Planning Application Reference No.: 3/2026/0426

Address of Development: Ribchester C of E Primary School, Ribchester PR3 3XP

Comments: I wish to object to the proposal to add a 1.5m (plus 14cm) high ball top metal fence on top of the existing stone wall on the Church Street and Riverside boundaries of the school.

Proposed Fence Elevation, Scale : 1:50

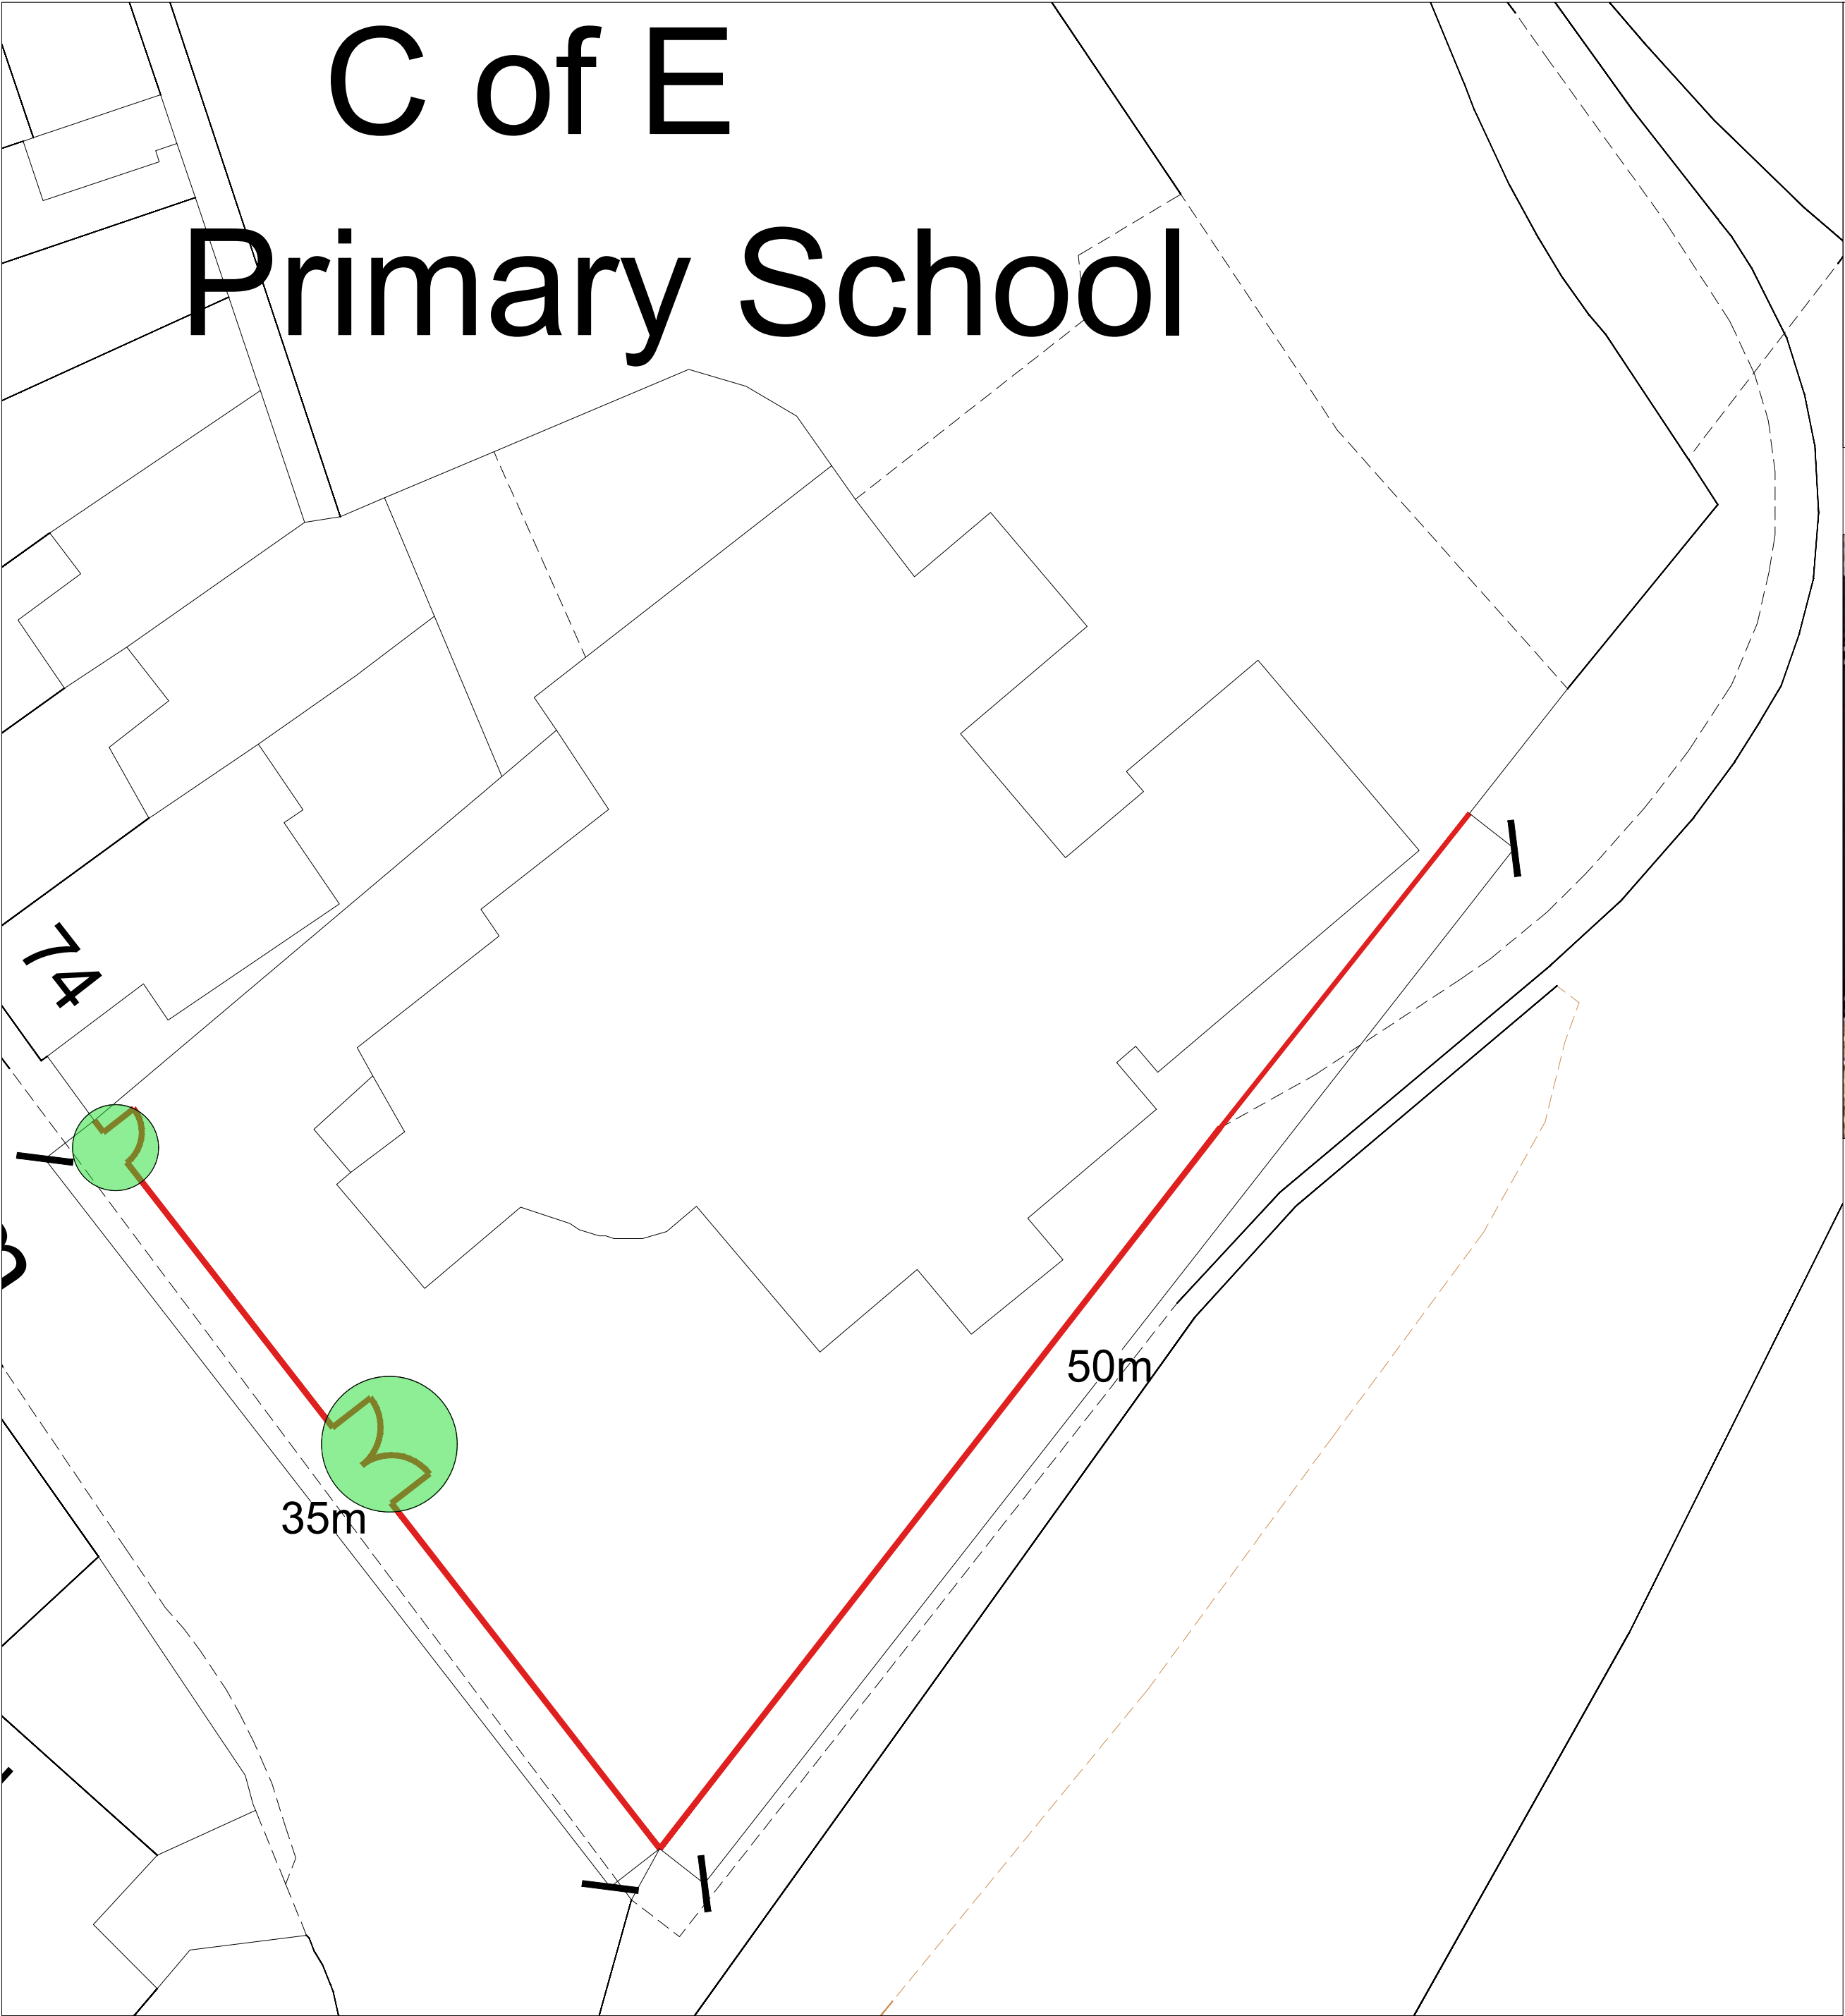
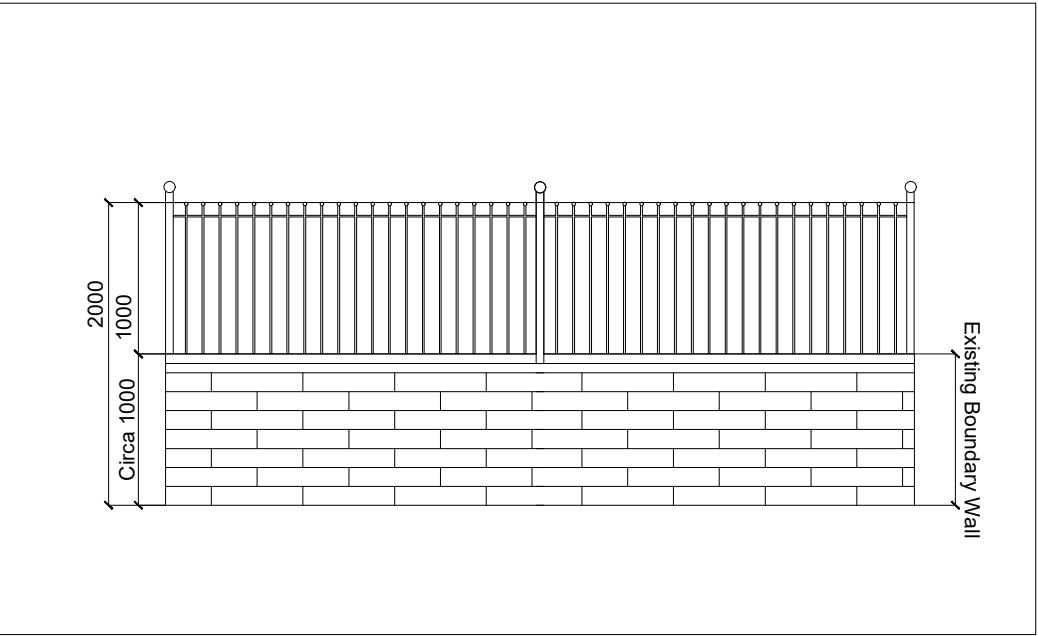
The plan indicates that the height of the existing wall is circa 100cm, with a proposed total height of 264cm or 8 feet 8". This may be the case within the playground, which has been levelled, but on the outside the Church St wall varies between 117cm and 140cm, and the Riverside wall is 170cm plus. This means that from external view the wall and fence combined will be from 281cm to 334cm, or from 9 feet 3" to 10 feet 11".

Proposed Fence Elevation, Scale : 1:50

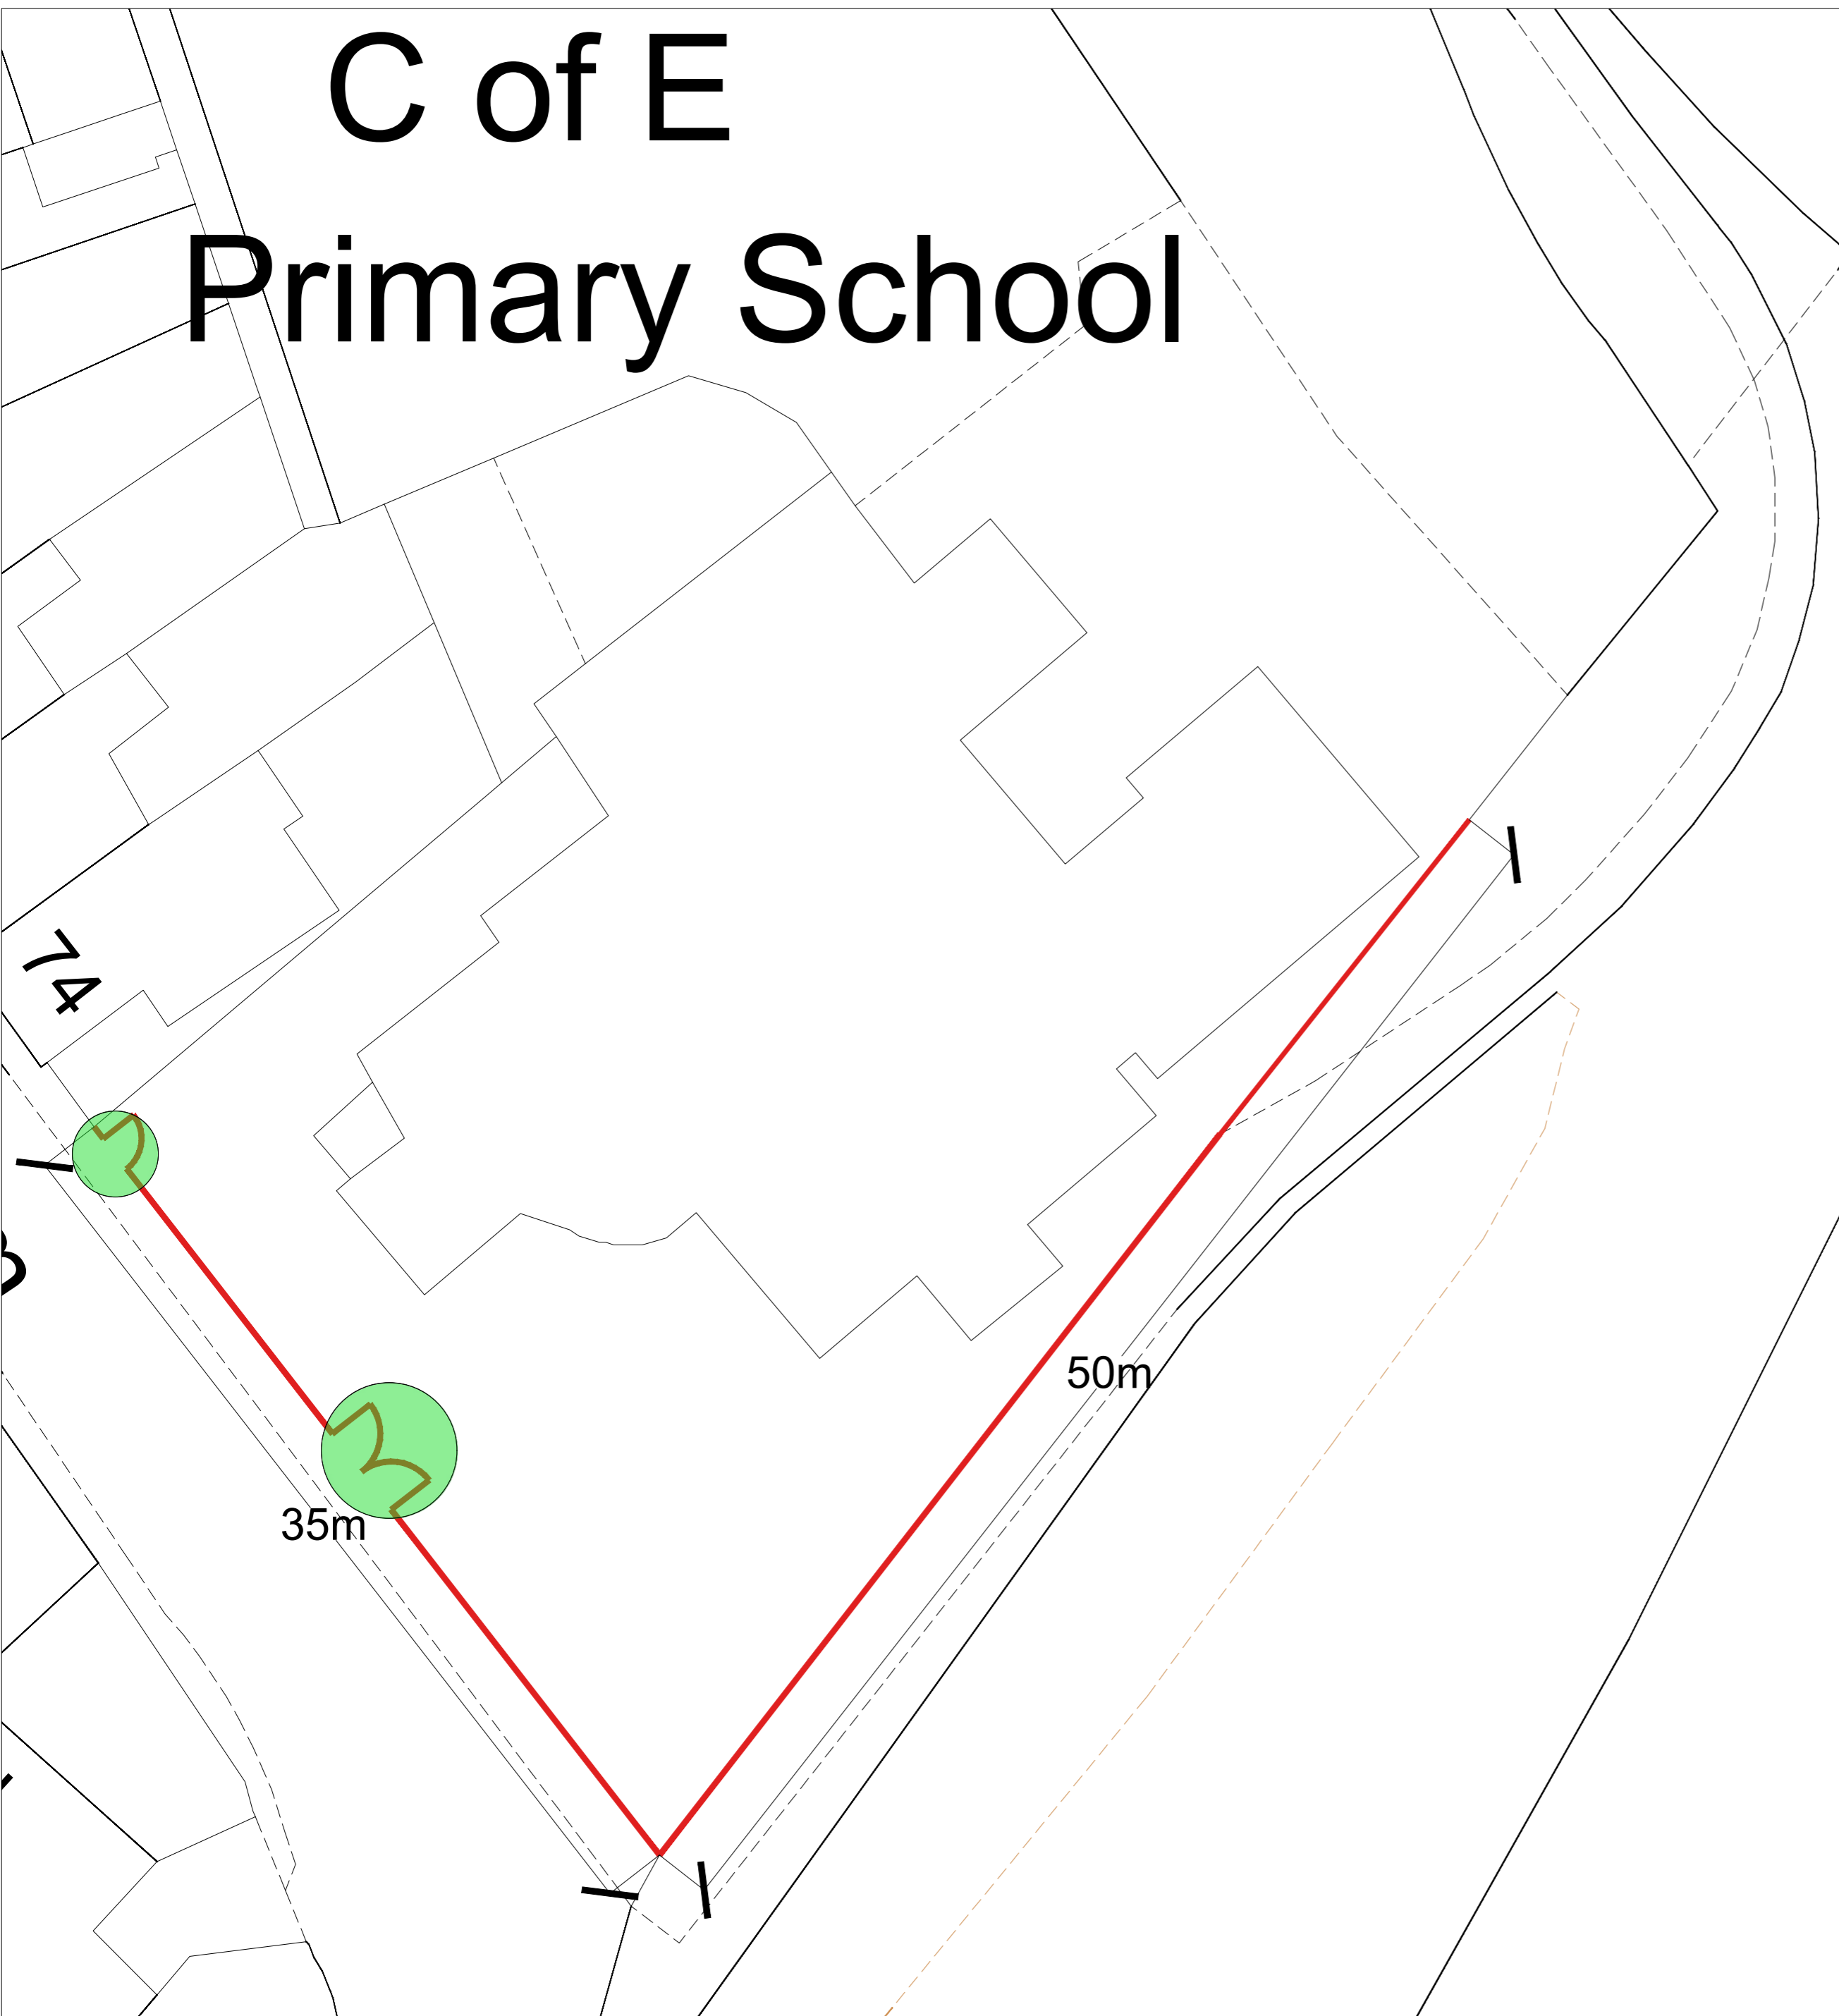
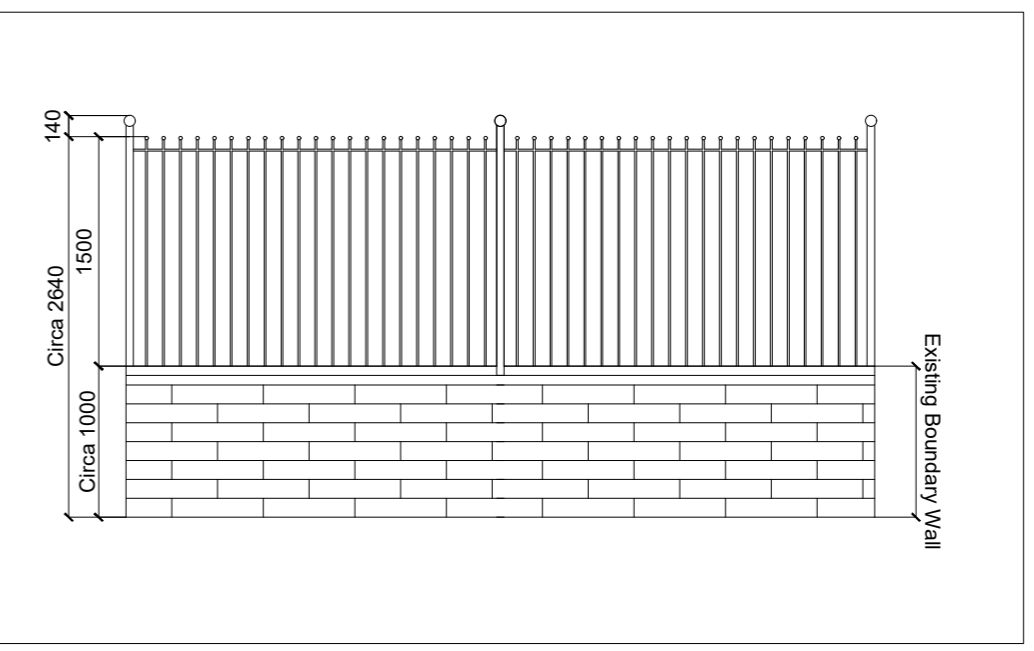
The basis of my objection is that railings of the proposed height are completely out of keeping with the village character and riverside appearance.

This feels absolutely disproportionate and not a 'positive contribution to local character and distinctiveness' as required by the local plan.
